Item No. Report of the Head of Development Management and Building Control

Address: 68 HATCH LANE HARMONDSWORTH

Development: Erection of a double storey side and part single, part first floor rear extension

LBH Ref Nos: 11905/APP/2023/2961

PROPOSED
GROUND FLOOR PLAN

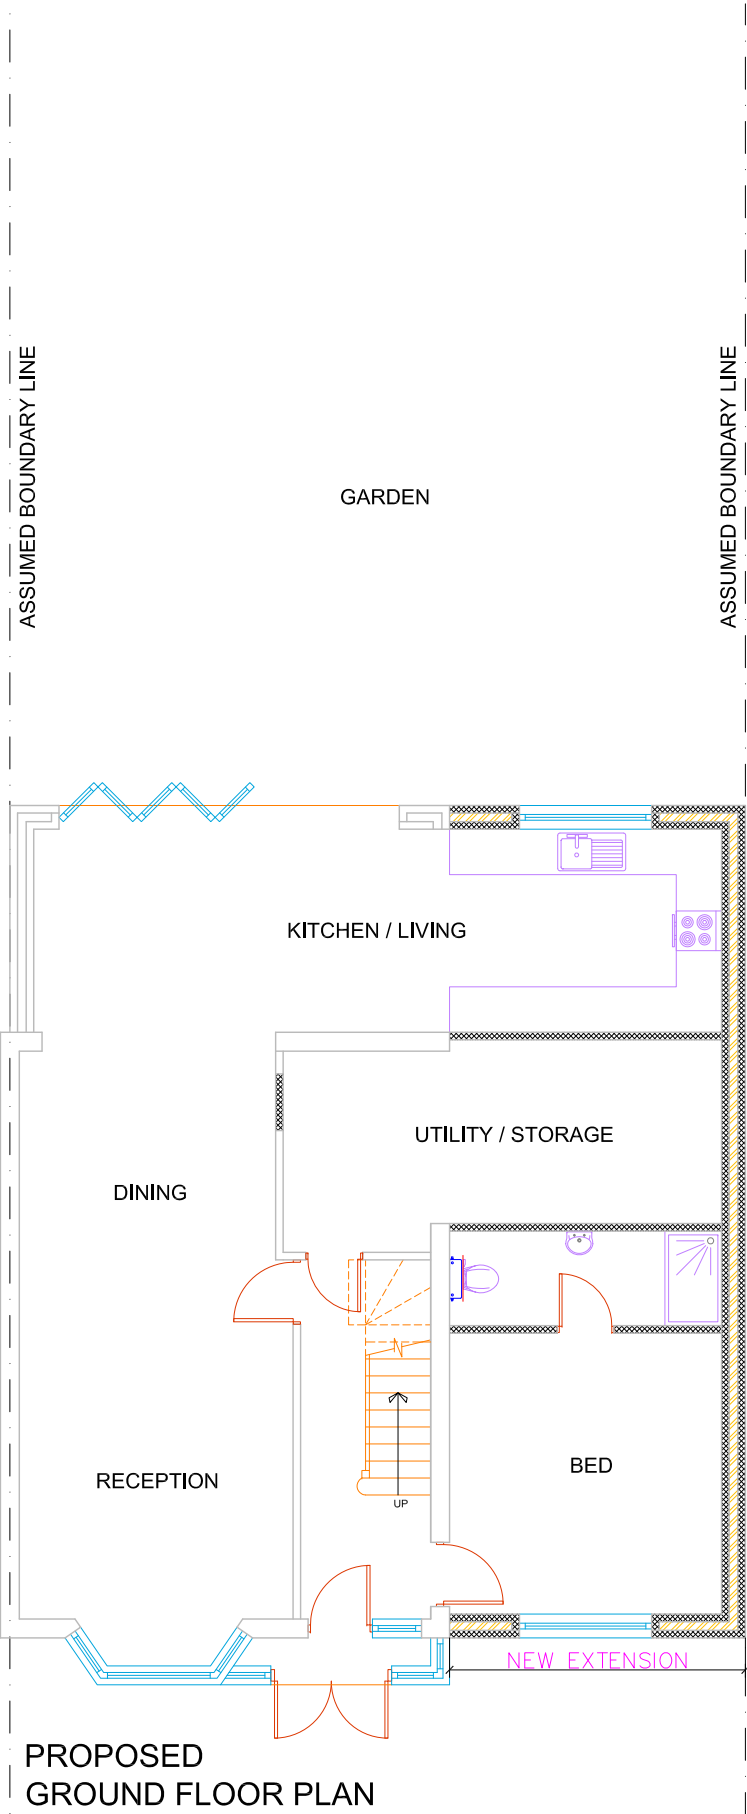
The proposed side extension would measure 3.90m in width which is over half the width of the original dwelling, 10m in depth and it would not be set in from the side boundary. It is set in 1m from the front elevation at first floor level and set down from the ridgeline. The extension would not comply with Policy DMHD 1. The proposed rear extension would connect to the proposed side extension and measure 3m in depth from the rear building line, 4.20m in width and 6.65m in height from ground level characterised with a pitched roof. The extension would form a disproportionate, overly dominant addition to the host dwelling.

Due to its excessive width, size, bulk and scale of the extension and its proximity to the side boundary, the proposal would form a disproportionate and overly dominant addition to the host dwelling which would fail to respect its original size or architectural composition, subsequently causing harm to its character and appearance. Furthermore due to the design and prominent corner plot location, the resulting property would appear unduly prominent and overdeveloped when viewed from the street scene, causing significant harm to the character and appearance of the surrounding area and Harmondsworth Conservation Area. The proposed development is therefore considered to be contrary to Policy BE1 of the Hillingdon Local Plan: Part One - Strategic Policies (November 2012), Policies DMHB 4, DMHD 1, DMHB 11 and DMHB 12 of the Hillingdon Local Plan Part Two - Development Management Policies (January 2020) and paragraphs 130 (a) and (c) of the NPPF (2021).

PROPOSED
FIRST FLOOR PLAN

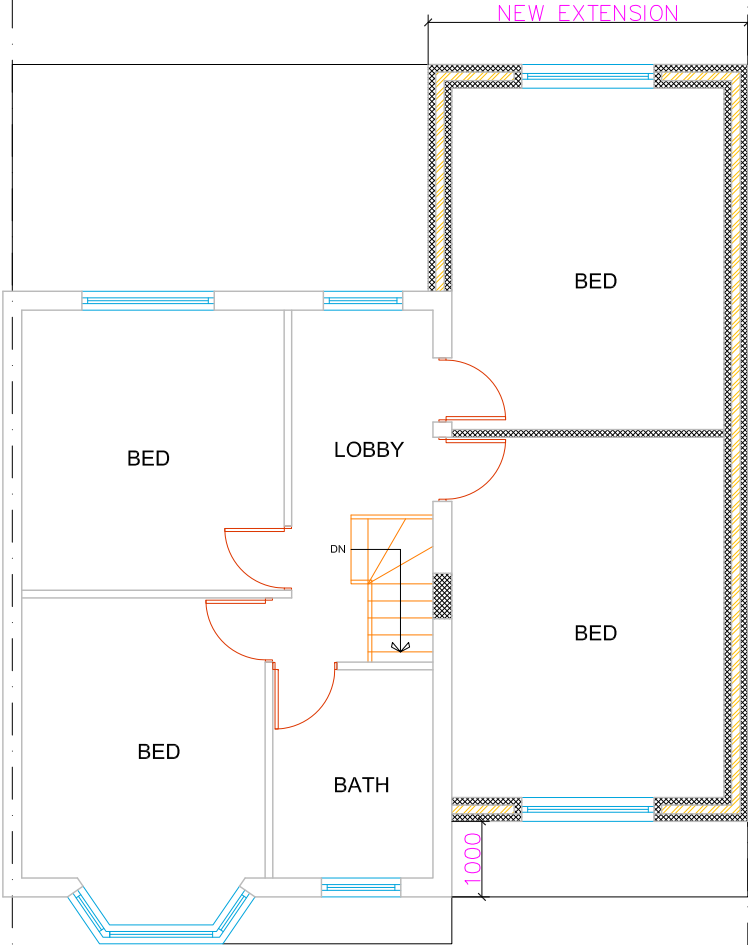
Number 1 Candover Close is located west of the application site. The proposed extension would include one new rear facing window at ground floor level and one new rear facing window at first floor level. This neighbouring property does not have any side facing windows, therefore no harmful overlooking or loss of privacy would be created. The windows would provide a similar outlook to the existing rear facing windows. As such there would be no harmful impacts to this neighbouring property.

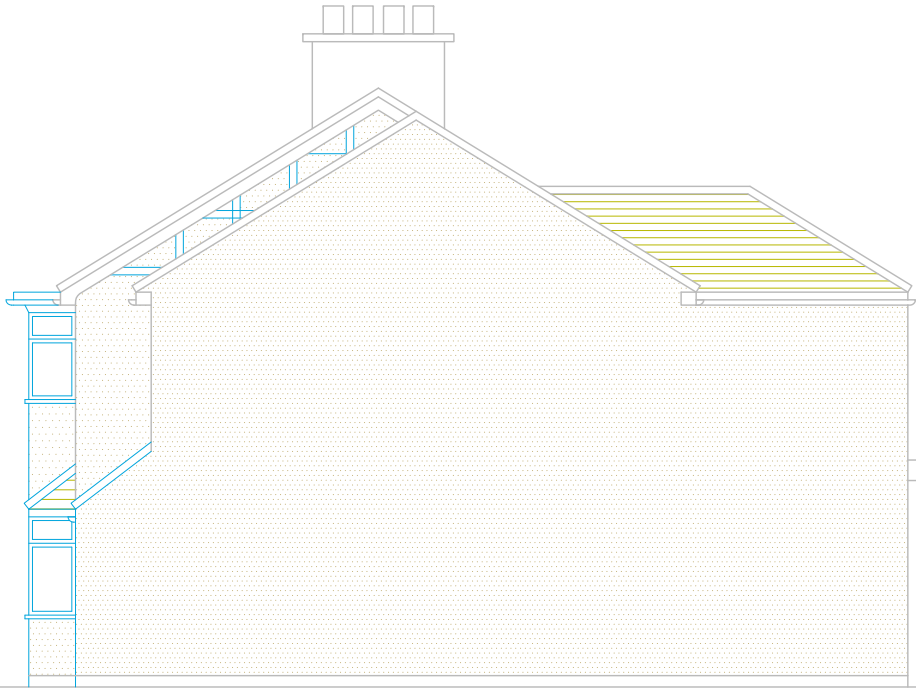
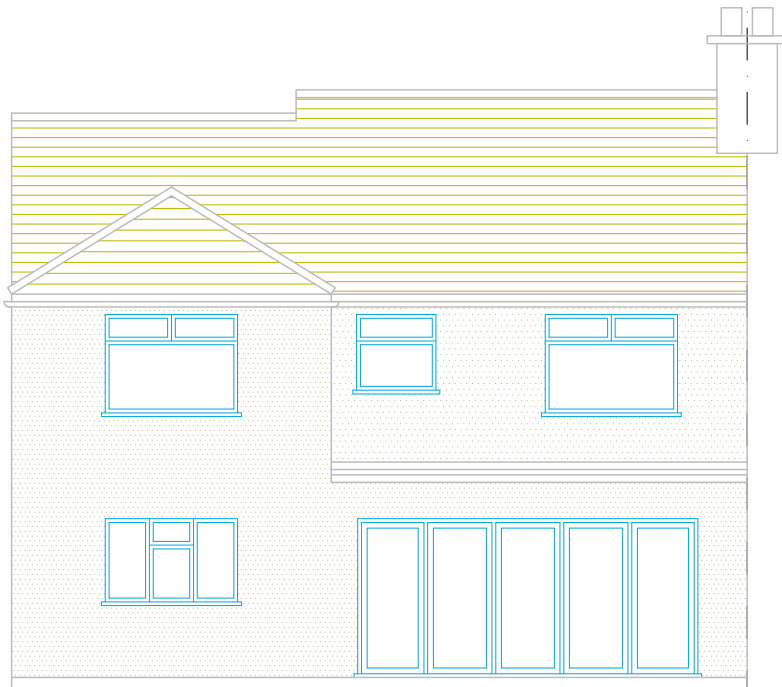
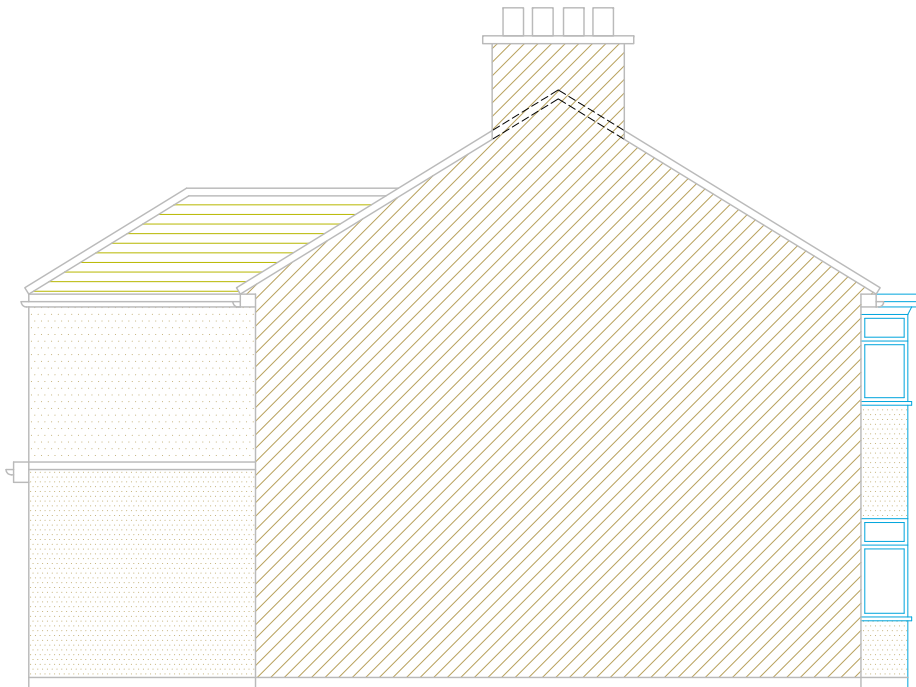
The dwelling is located on a prominent corner plot meaning the proposed extensions would be readily visible from multiple public vantage points. Due to the design, size, bulk and location, the proposed extensions would form an excessive, over dominant and unduly prominent addition to the street scene, harming the appearance and character of the area and consequently harming the Conservation Area.
